**WELWYN HATFIELD COUNCIL – DEVELOPMENT MANGEMENT**  
**DELEGATED REPORT**

<b>APPLICATION No:</b>	<b>W6/2012/1689/EM</b>
<b>APPLICATION Site:</b>	<b>35 Sherrardspark Road, WGC</b>

The application proposes to erect a dormer window on the south - western elevation of the property. The proposed dormer window would measure approximately 2.2 metres wide, 1.6 metres tall and 1.6 metres deep.

PROJECT	35 Sherrards Park Road	AMA DESIGN
DRAWING TITLE	Proposed Elevations	
STATUS	Planning	
SCALE 1:100 © A3 DRAWN BY	AM 08 - 004P

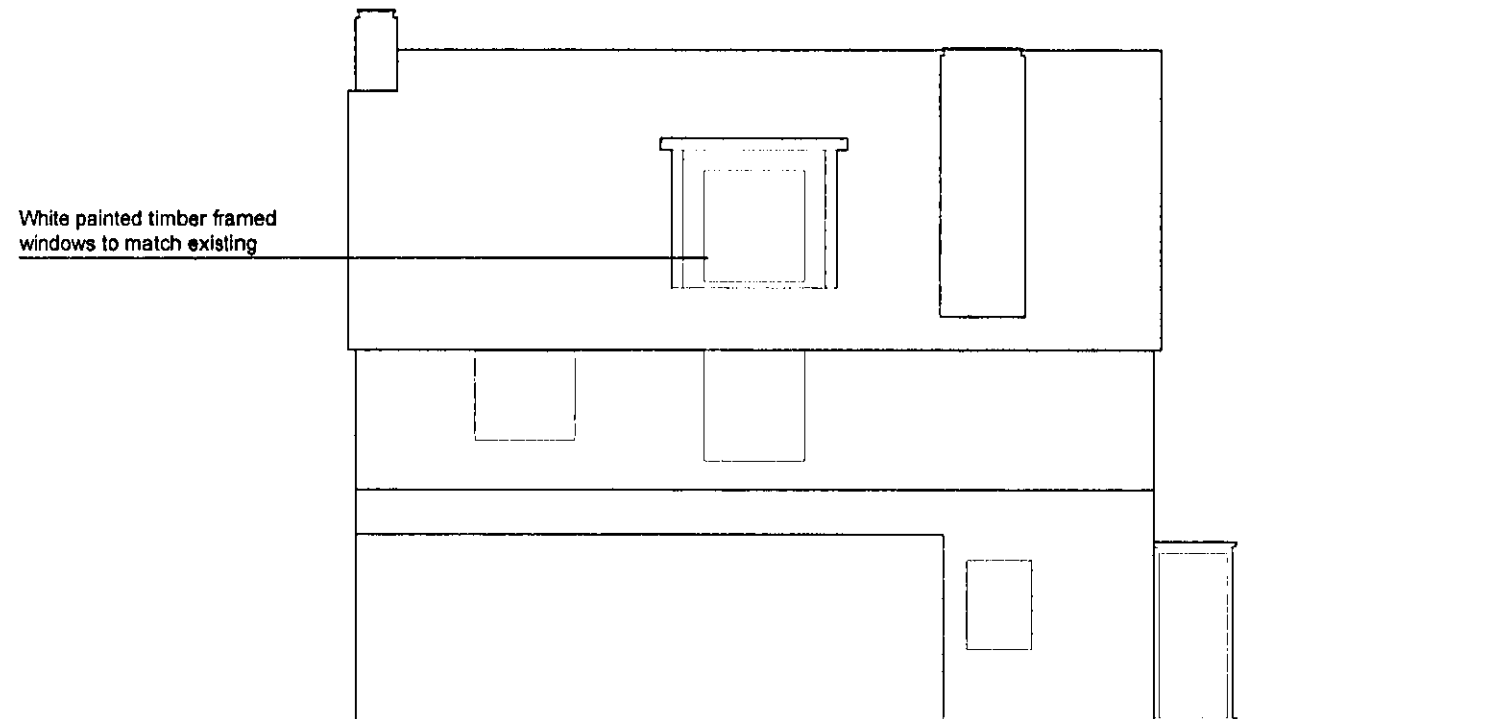
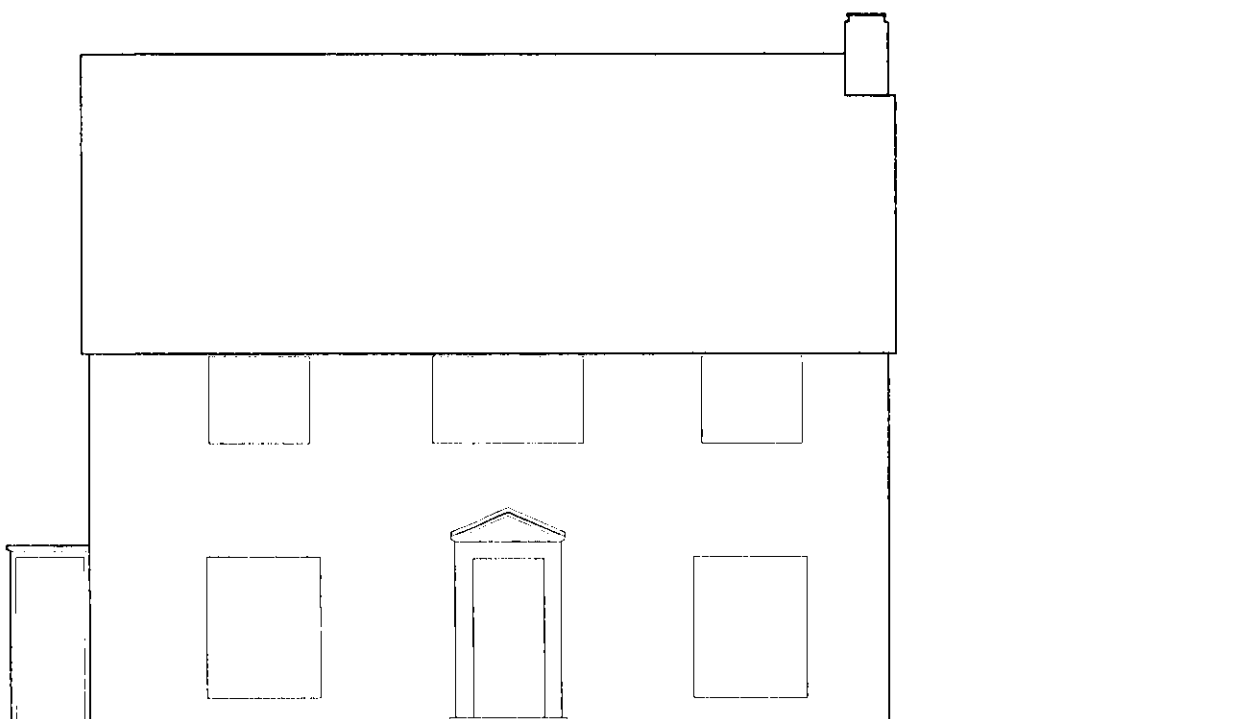
In terms of the proposed dormer window, it is considered that the existing roof form of the dwelling is simple and uninterrupted. The proposed dormer window would be constructed of materials and fenestration to match the existing dwelling and would be used to serve a staircase to a room that would not be used for habitable accommodation.

The proposed dormer windows would be significant in width which would not be considered to subservient to the roof of the property. However, the applicant has provided supporting information to demonstrate that there are examples of substantial dormer windows in the area surrounding the application site. Reference has been made to examples of dormer windows at 44 and 45 Sherrardspark Road, 18 Roundwood Drive, Mandeville Rise and 7 The Glade. These provide examples of substantial dormer windows, with 44 and 45 Sherrardspark Road being in close proximity to the application site. The scale of the dormers at 44 and 45 Sherrardspark Road are larger than the fenestration at lower levels on the properties (in height at 45 and width at 44). The other examples offered by the agent for the application are not considered to be within the direct vicinity of the application site and therefore their presence can only be given limited weight in considering the current proposal. In addition to 44 and 45 Sherrardspark Road there are examples of dormer windows that were approved in 2008 on the rear of 41 Sherrardspark Road, and these have remained subservient to the roof of the property.

The larger dormer windows that were approved on the above mentioned neighbouring properties is a consideration when determining this application. The fenestration in the dormer windows on neighbouring properties also either reflects the width or height of existing windows within the properties, whereas the proposed window does not do this.

In this instance the proposed dormer window would fail to remain subservient to the roof of the property which would be to the detriment of the character and appearance of the property and the surrounding area and the amenities and values of Welwyn Garden City. The proposal would therefore be contrary to policy EM1 of the Estate Management Scheme.

1. The proposal by virtue of the scale of the proposed dormer window would fail to remain subservient to the roof of the property, which would be to the detriment of the character and appearance of the property and surrounding area. The proposal would therefore be contrary to policy EM1 of the Estate Management Scheme and would fail to sufficiently maintain the amenity and value of Welwyn Garden City.
